From: Hannah Riddle on behalf of Planning.Responses
Sent: 26 April 2022 16:20
To: Planning Scanning
Subject: FW: Planning Re-Consultation on: Y/32/22/DOC

Engineers Comments Regarding Condition 8

Application No: Y/32/22/DOC
Registered: 8th March 2022
Site Address: 10 Acre Field Grevatts Lane West Yapton Bognor
Grid Reference: 498000 101780
Category: Discharge of Condi

Description of Works: Approval of details reserved by condition imposed under ref W/4000394 (Y/102/18/PL) relating to Condition Nos 8 - surface water drainage and 10 - maintenance & management of surface water drainage system.

Typical swale/basin gabion outfall detail

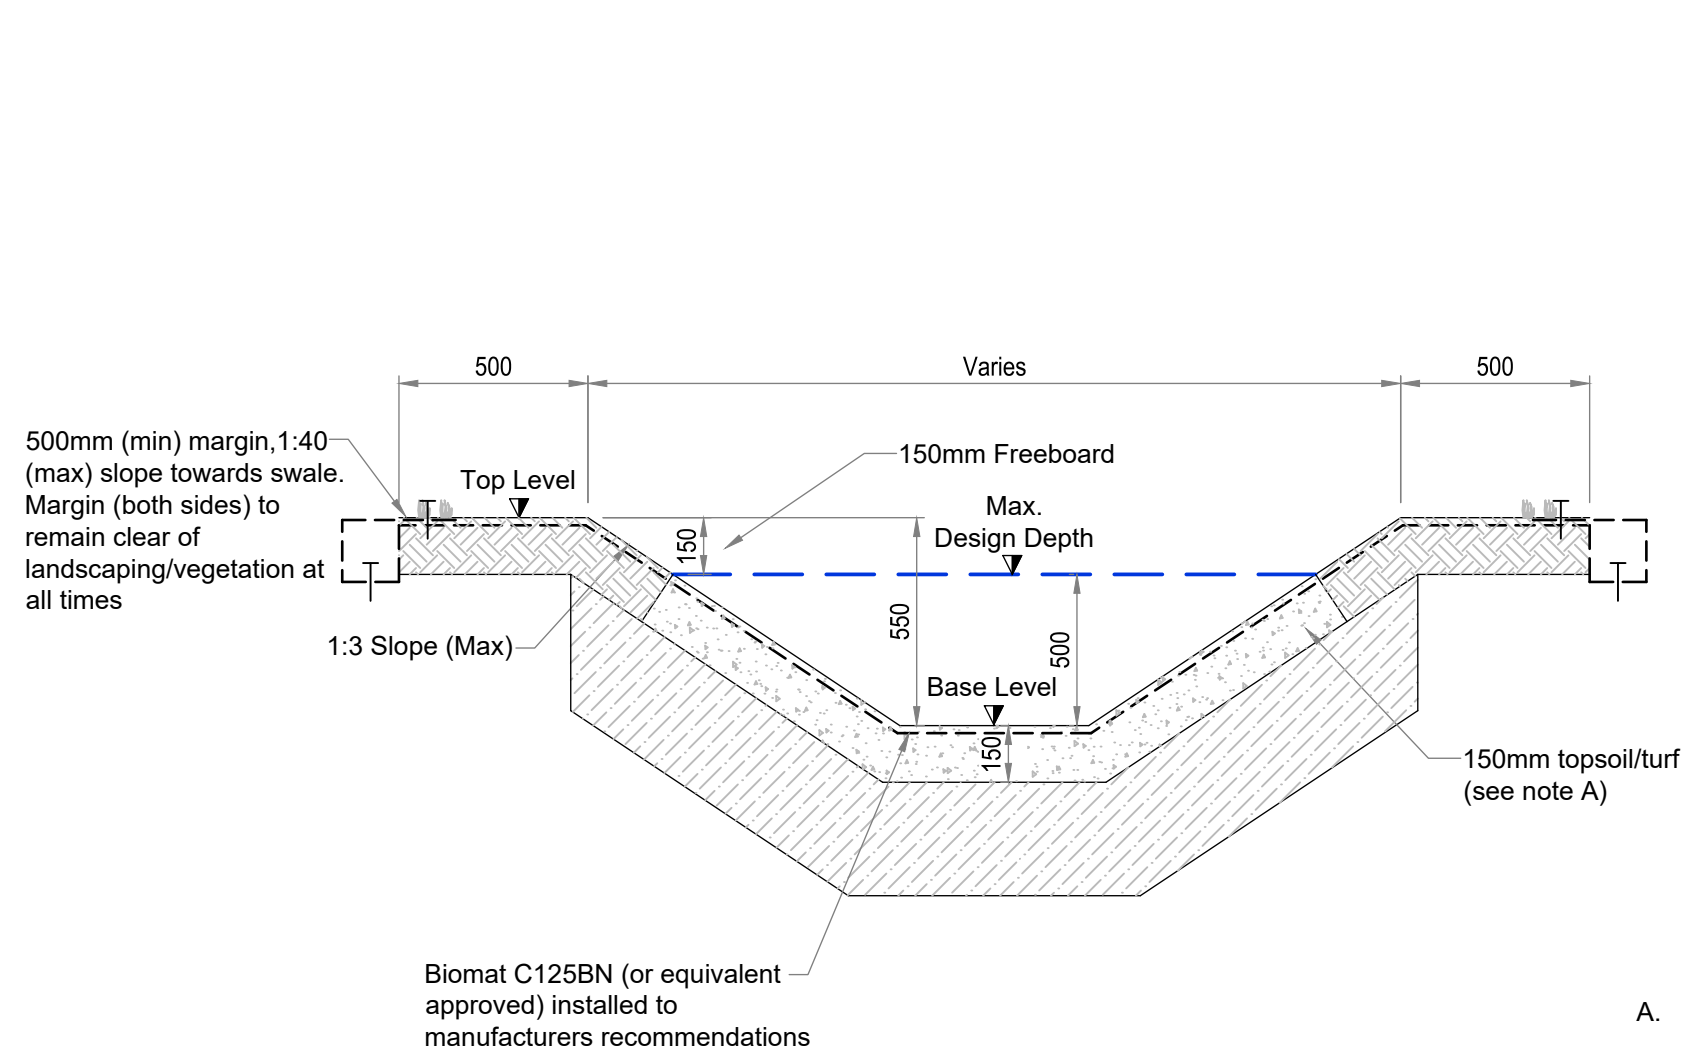
8. The gabion outfall construction detail drawing is unclear. Is it proposed to have buried pipes discharging to the basin? The gabion basket is to be built into the embankment and to be exposed so as to be accessible for maintenance. The pipework will be within the basket and wrapped in a permeable membrane to prevent build-up of fines. The gabion provides siltation protection as well as dispersal of incoming flow to reduce scour. The gabion basket also removes the need for a traditional headwall and grille, reduces the maintenance requirements and provides a bigger area of contact/surface flow. *Pipework should be exposed and within headwalls. To bury pipework within a gabion will prevent visual inspections for blockage being undertaken. The permeable membrane surrounding the pipe and gabion will likely silt up. Design must be maintainable. The gabion basket headwall is designed to minimise impact to the visual impact vs traditional precast concrete headwall units while allowing free flow of water. The headwalls proposed have been successfully utilised on other schemes and have been encouraged by other drainage authorities; an example can be found on page 76 of the Cambridge SuDS design and Adoption Guide (attached for reference). We do not accept the proposals, as detailed previously "Pipework should be exposed and within headwalls. To bury pipework within a gabion will prevent visual inspections for blockage being undertaken. The permeable membrane surrounding the pipe and gabion will likely silt up. Design must be maintainable"*

Project No.	Originator	Volume	Lvl/Loc	Type	Role	Number	Rev
13591	CRH	XX	XX	DR	C	5050	P6

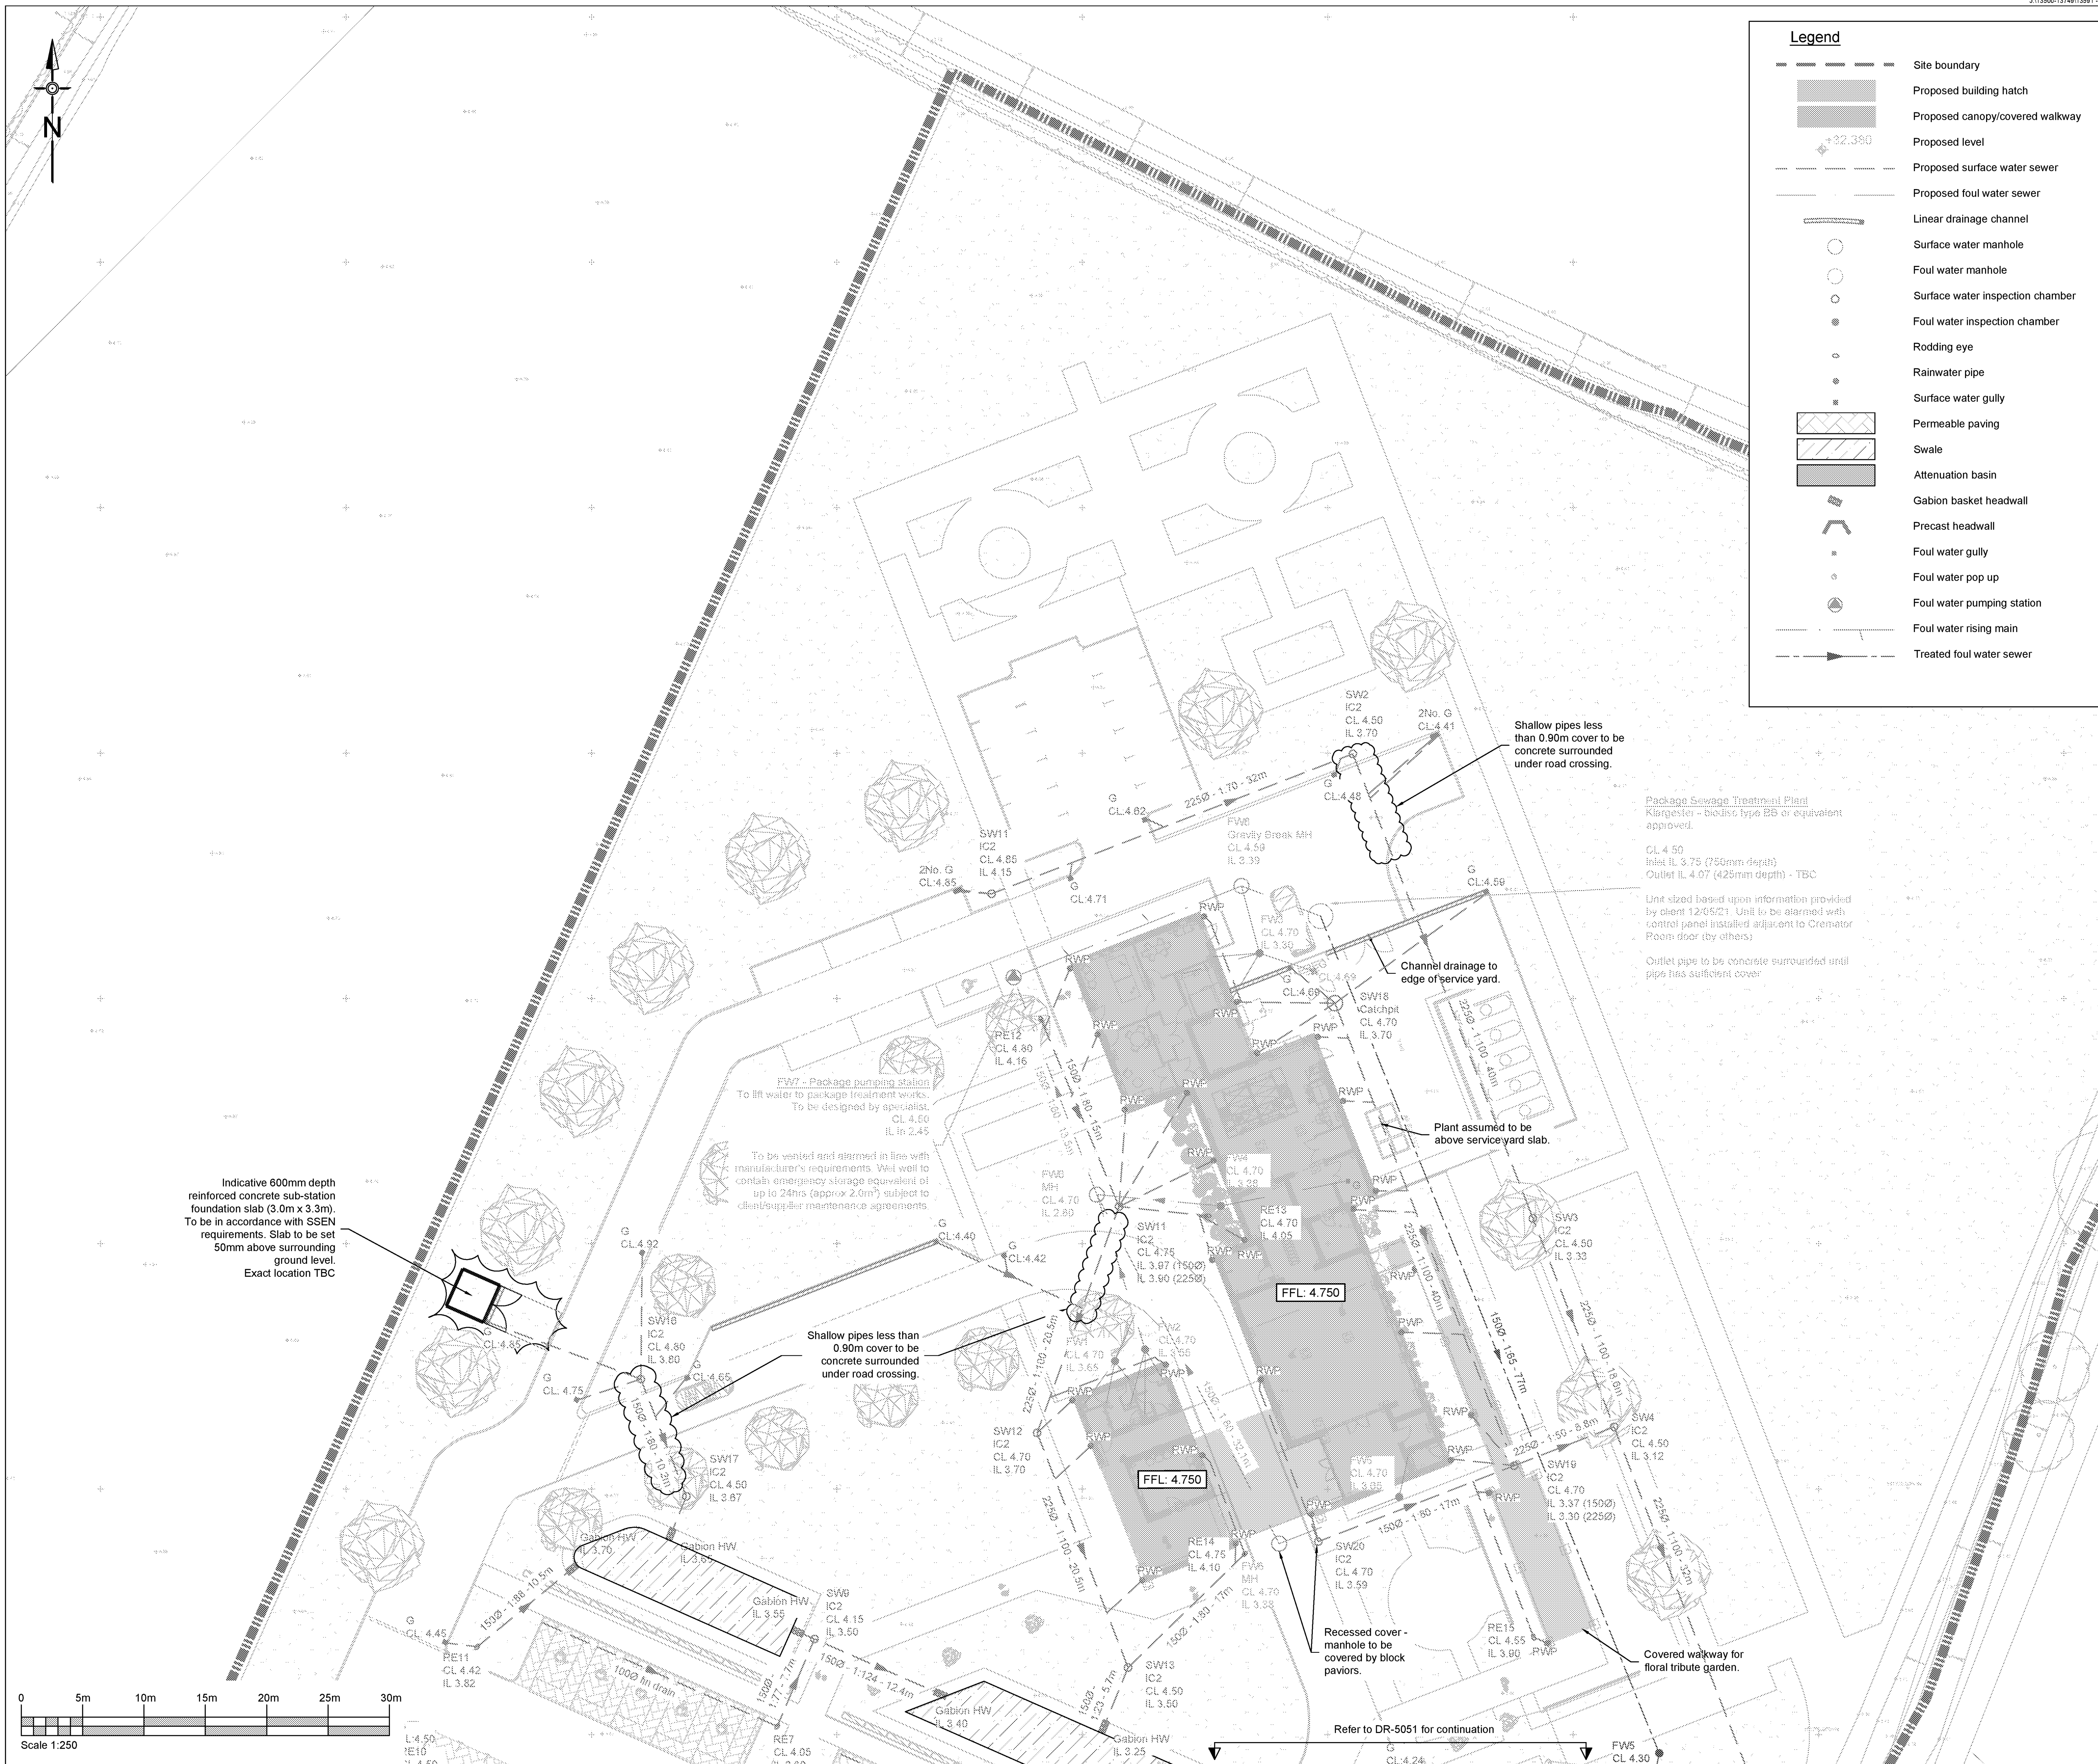
4. Please label all pipes with diameter and fall. Additional pipe labels have been added to drainage layout plans 13591-CRH-XX-XX-DR-C-5050 Revision P6 and 5051 Revision P5. Gradients for short (<5m) pipe lengths have not been shown. Pipe sizes, maximum grades and materials are to be as specified on drainage notes drawing 13591-CRH-XX-XX-DR-C-5300 Revision P1 previously provided. Okay.

7. Gullies and channel drains should be labelled with cover levels. Cover levels have been provided for proposed gullies on updated drainage layout plan 13591-CRH-XX-XX-DR-C-5050 Revision P6 and 5051 Revision P5. Channel drain cover levels will necessarily vary along the length and hence have not been provided. Exact levels will be determined by contractor to suit the finished levels as shown on levels plan 13591-CRH-XX-XX-DR-C-5200 Revision P3. *Levels should be provided on plan to ensure construction is carried out in accordance with proposals. Channel drain cover levels have been added to drawings DR-5050 and 5051 as requested. To be reviewed once an updated set of calculations is provided.*

Revision PS. Buffer not clearly shown, please show the buffer on a plan. A buffer has been shown on drawings DR-5050 and 5051 as requested. Okay.

Project No.	Originator	Volume	Lvl/Loc	Type	Role	Number	Rev
13591	CRH	XX	XX	DR	C	5051	P5

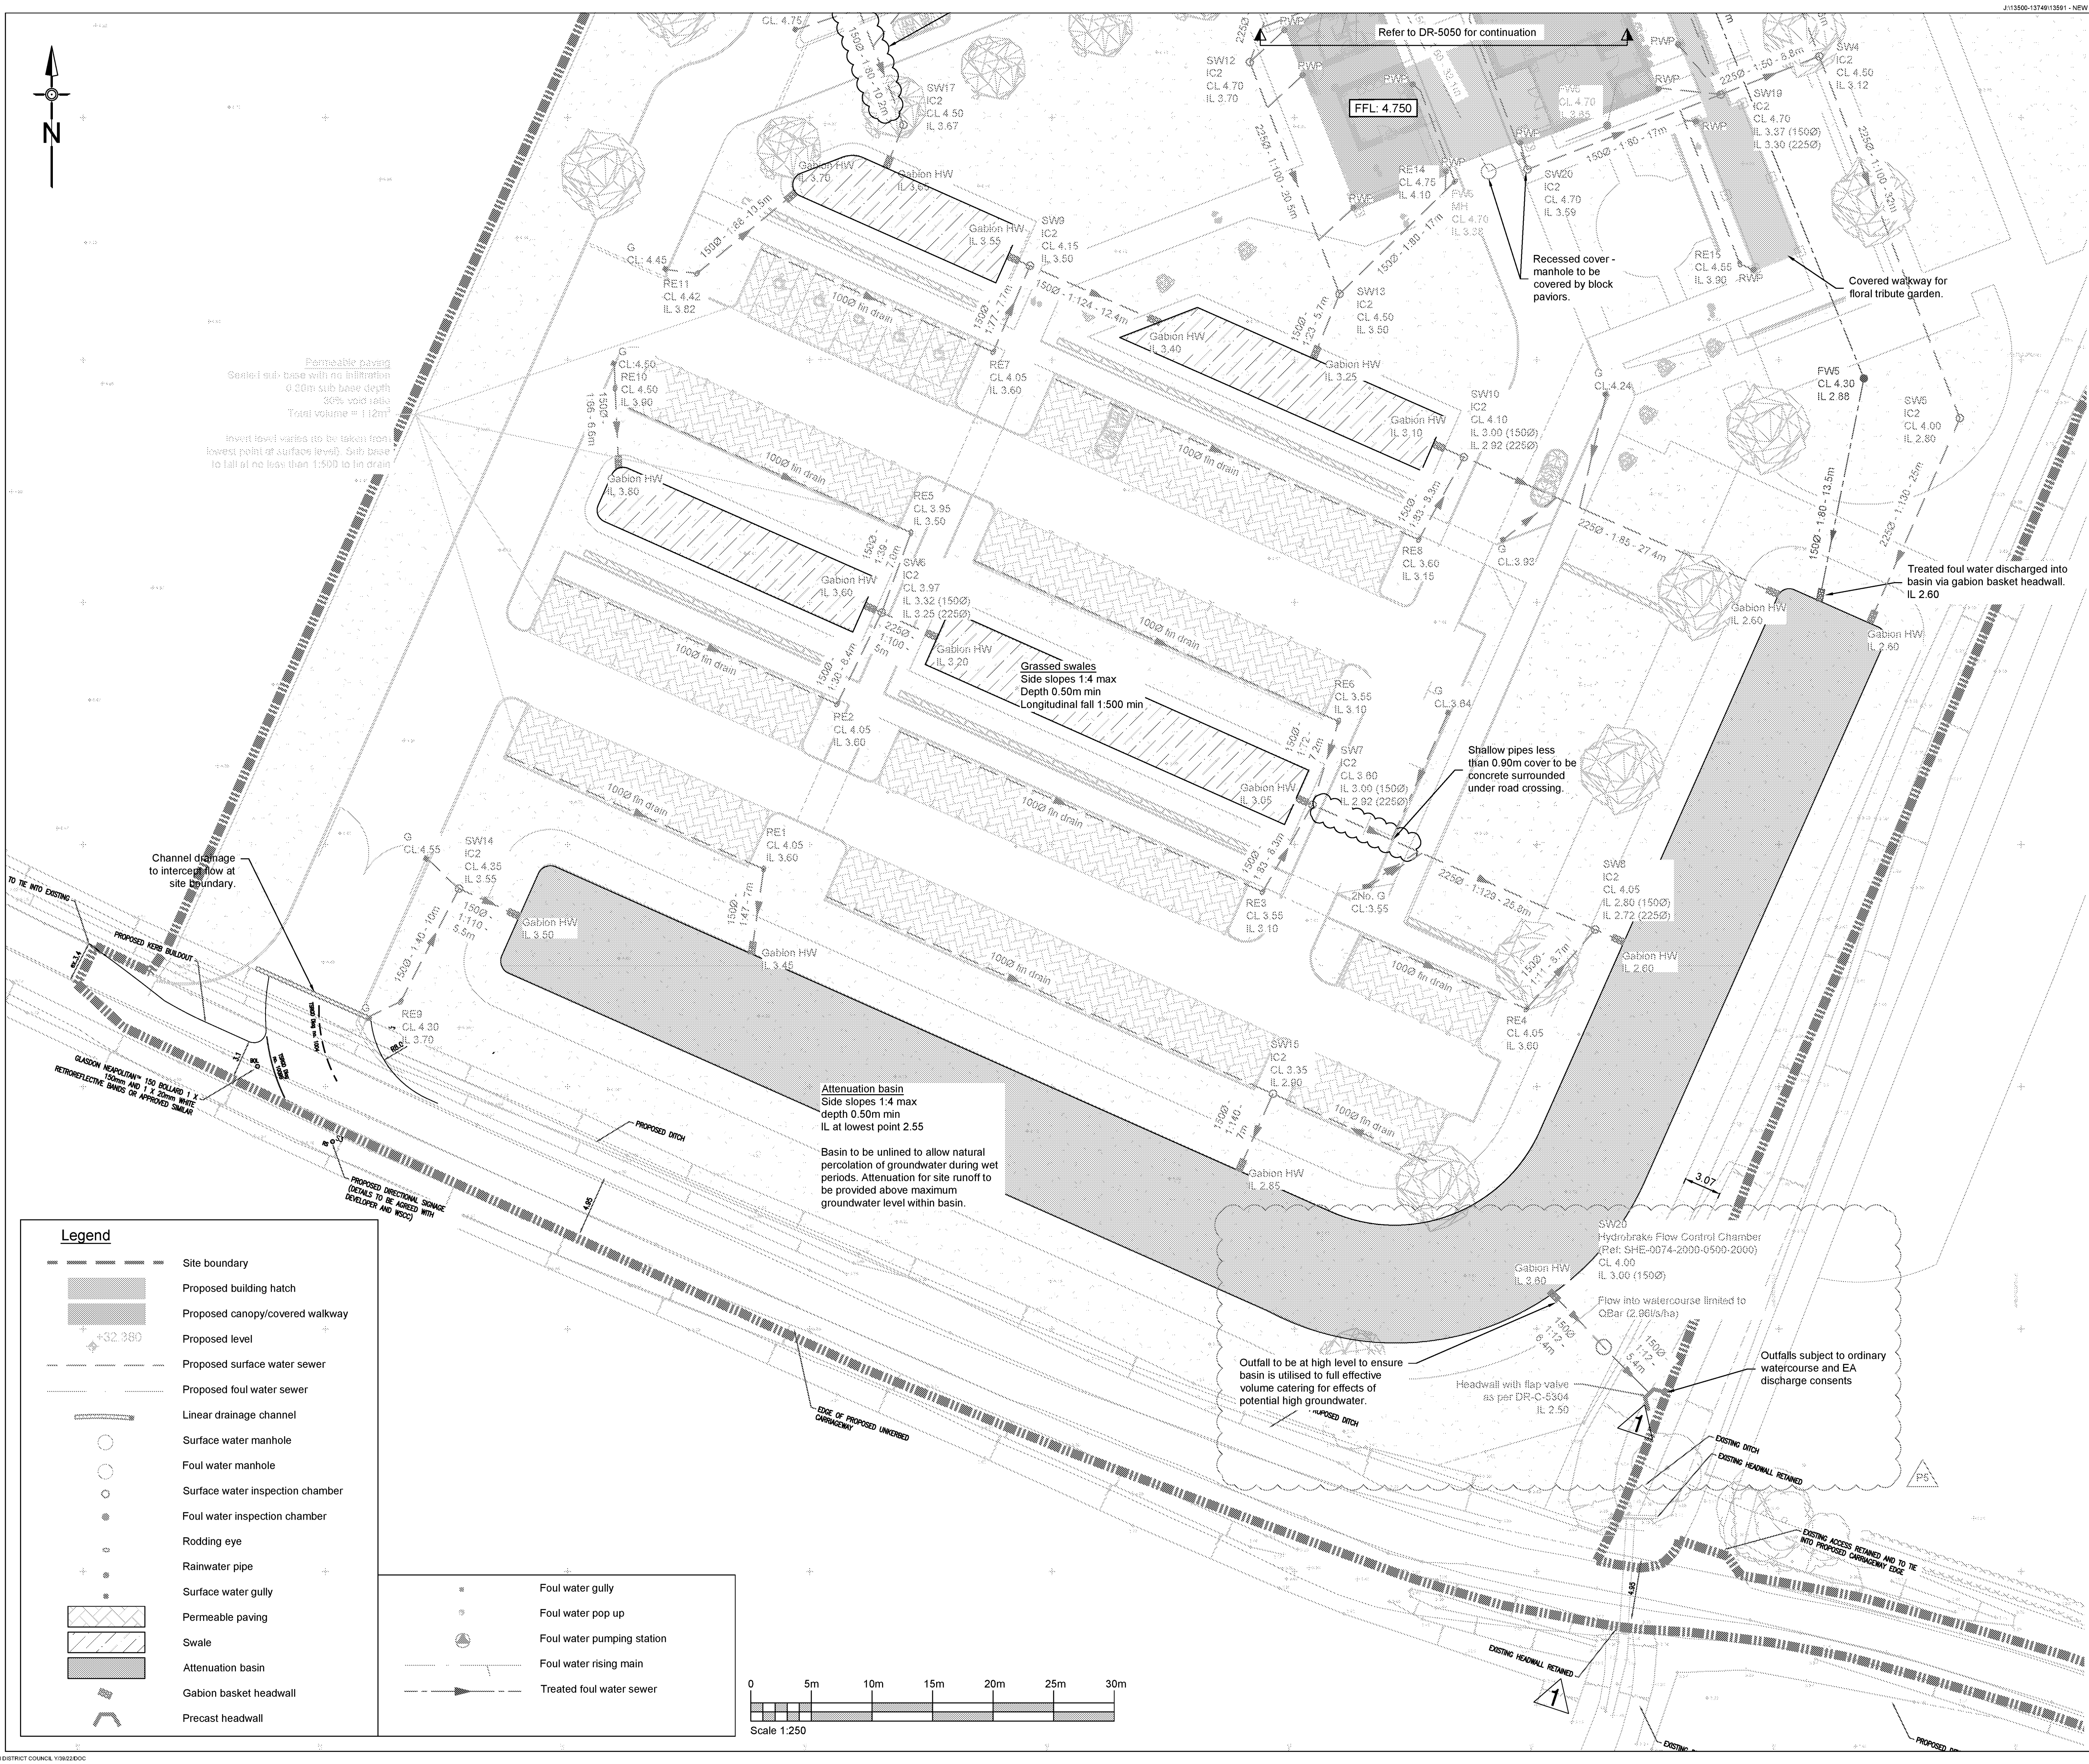
5. Hydrobrake unit references should be included on layout plans. Details have been added to updated drainage layout plan 13591-CRH-XX-XX-DR-C-5051 Revision P5. Okay, but please see comment above for more detailed calculations to evidence a compliant design. *Hydrobrake reference on plans matches the calculations.*

2. Please supply a buffer plan to show that at least 3m is being provided between top of bank of watercourses and obstructing features, such as fences, buildings, and basins. A suitable buffer has been provided between top of basin and edge of watercourse to allow for maintenance, as shown on drawing 13591-CRH-XX-XX-DR-C-5051
